Recommendation Report

Application No. Aw/16/13/

Development Single storey extension
Location Aldwick British Legion 20 Hewarts Lane Aldwick

sheet 2 of 3

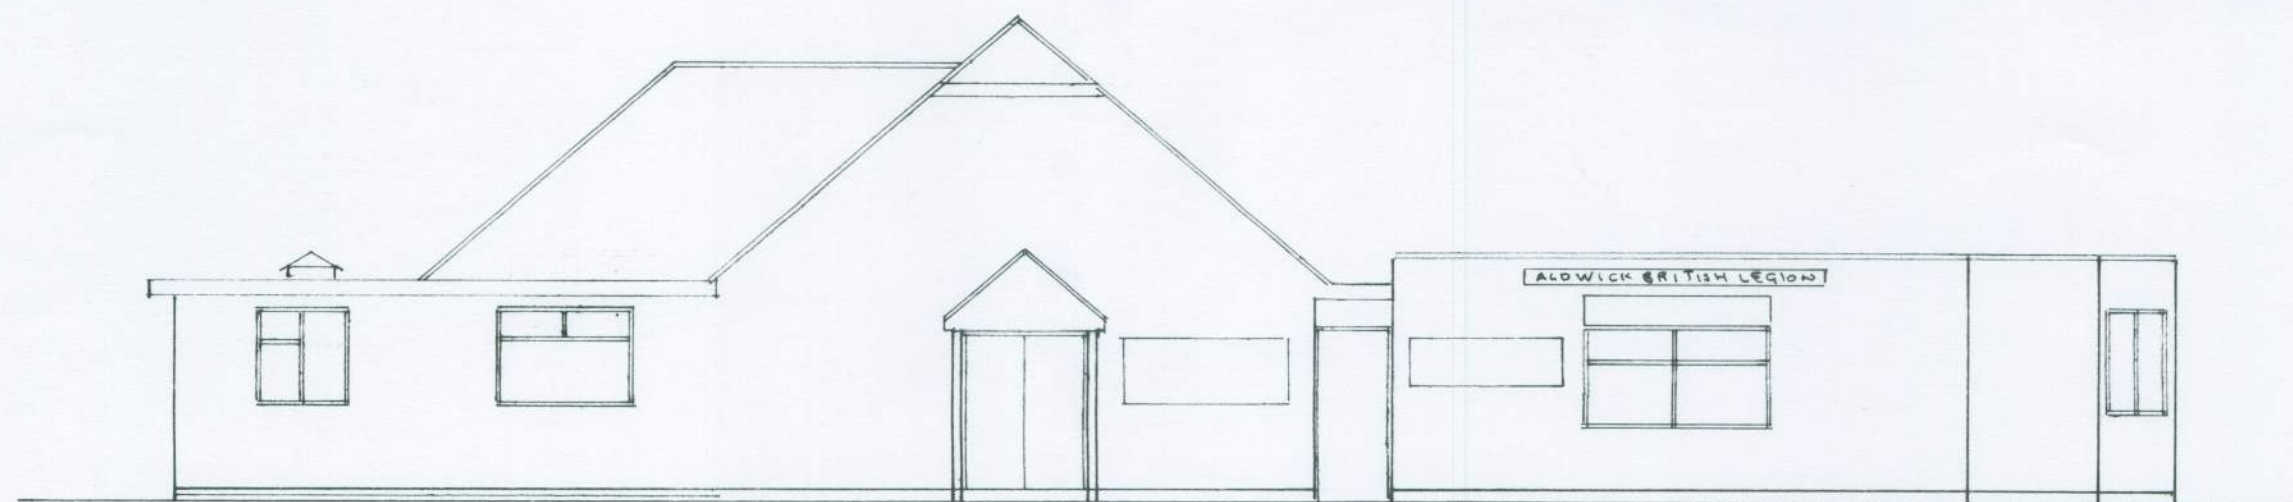
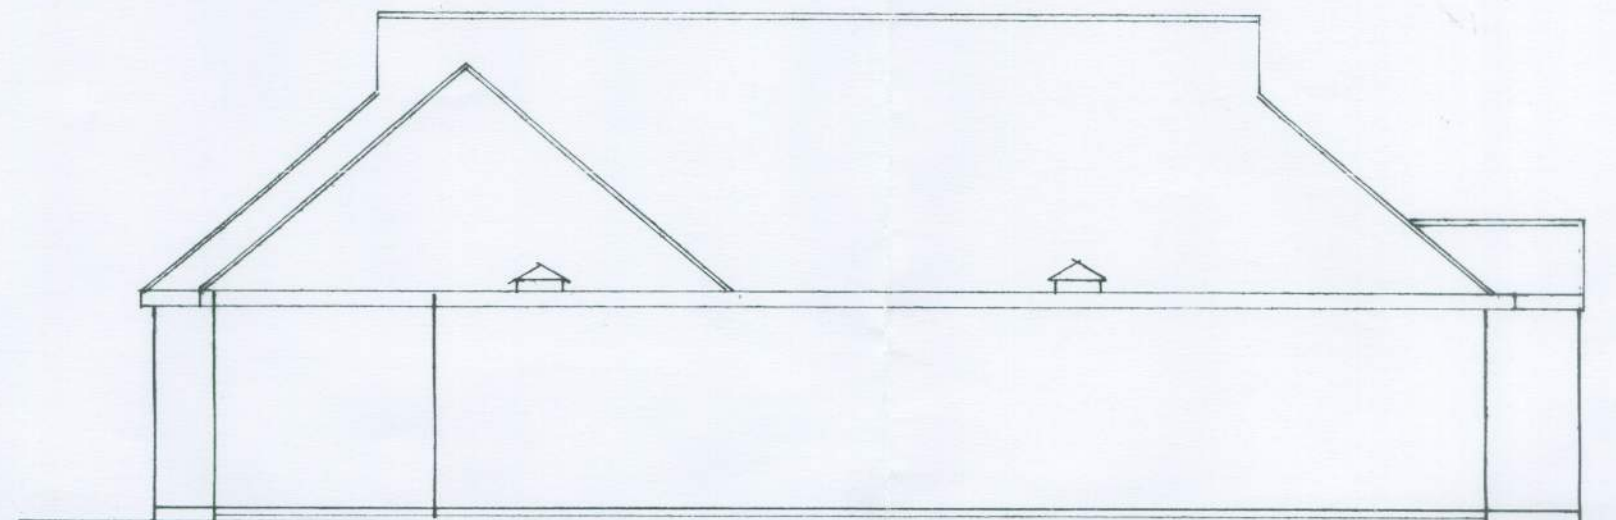
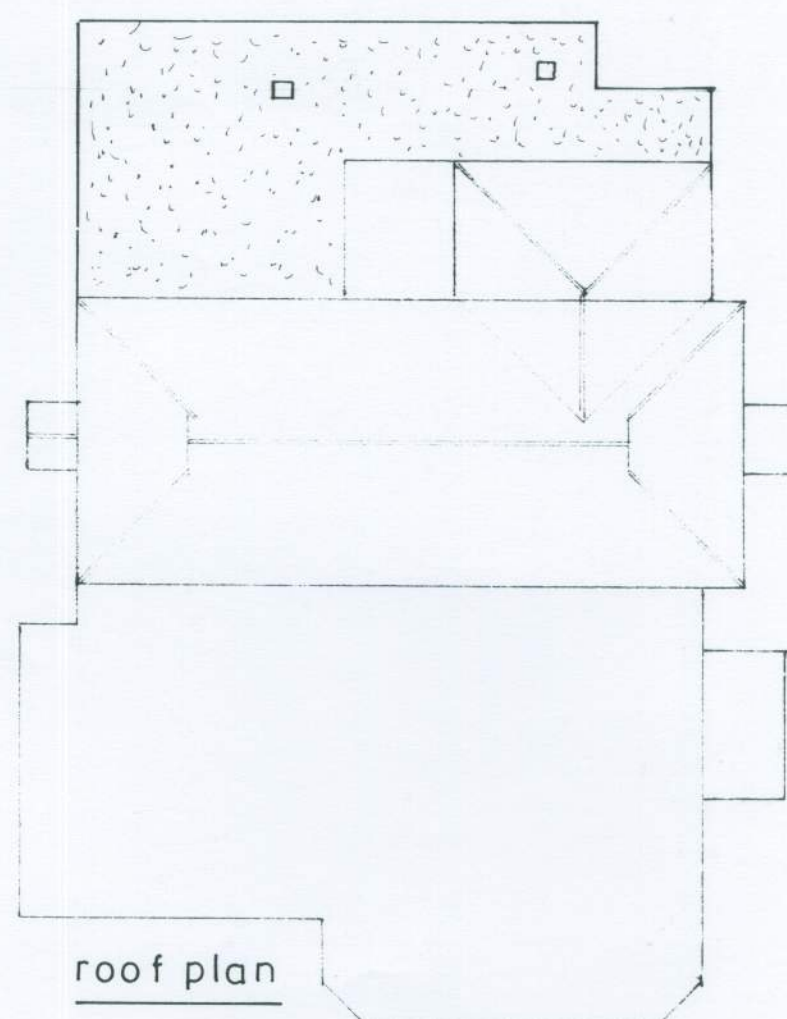
Please confirm what the 2 empty rectangle boxes are between the door and the windows. If they are windows then please amend the floor plans provided.

The areas in question are not windows they are existing notice boards.

block plan

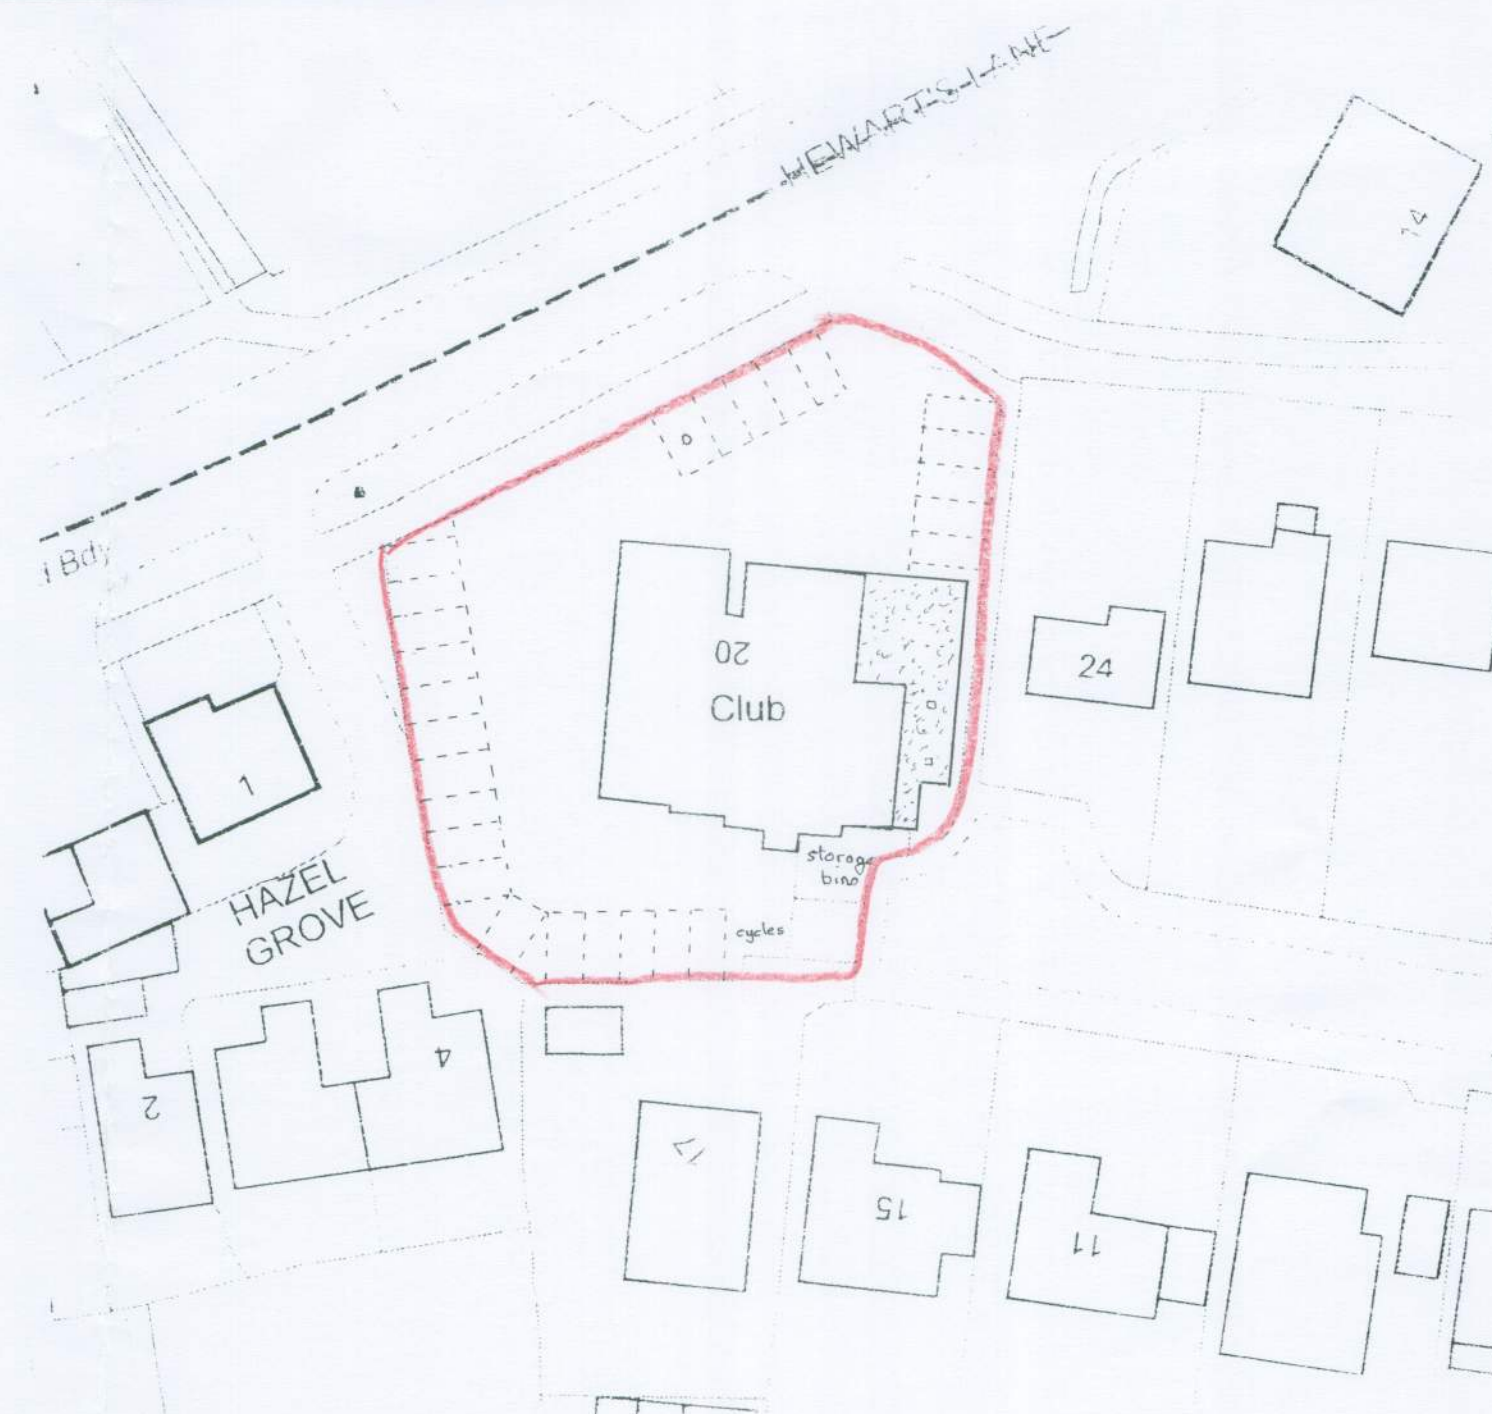
Please submit 1 electronic or 3 paper copies of a revised location plan and block plan as the red edges do not match in accordance with the guidance notes available on our website detailed below (click on National List).

I attach red edged block and location plans as requested.
